From: Mick Morris <[REDACTED]>
Sent: 12 July 2019 19:06
To: Planning.Responses <[REDACTED]>
Cc: Matt Stovel [REDACTED]
Subject: Re: Further Information Required on Your Ref: PP-07991005 Our Ref: P/66/19/HH

Thankyou for your letter,I enclose the further requested information for the above householder application, reference no P/66/19?HH.

North Elevation ProposedNo existing rear North elevation 1:100

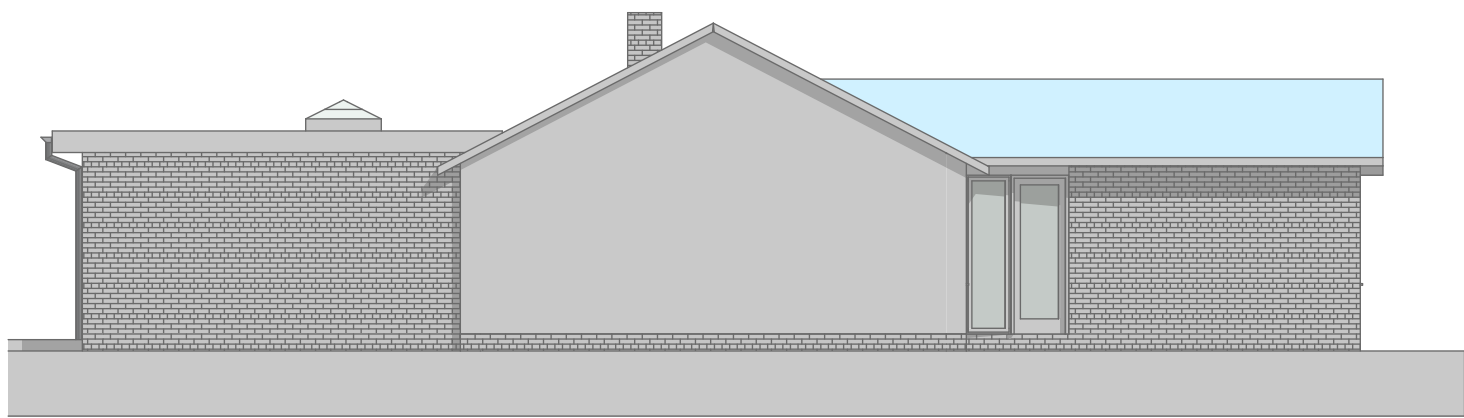
- A. There is a Block Plan at 1,500 showing the full garden and surrounding properties.
- B. A North elevation proposed, there being no existing north elevation.
- C. A request to extend the garage is not a part of this application.

I have endeavoured to reduce the impact of the roof edge slightly by incorporating some of the roof composition within the masonry so this is shown as a 285 deep fascia.

The internal floor to ceiling height is matching the existing dwelling's ceilings at 2,300 mm. The gross roof thickness is actually 385 mm.
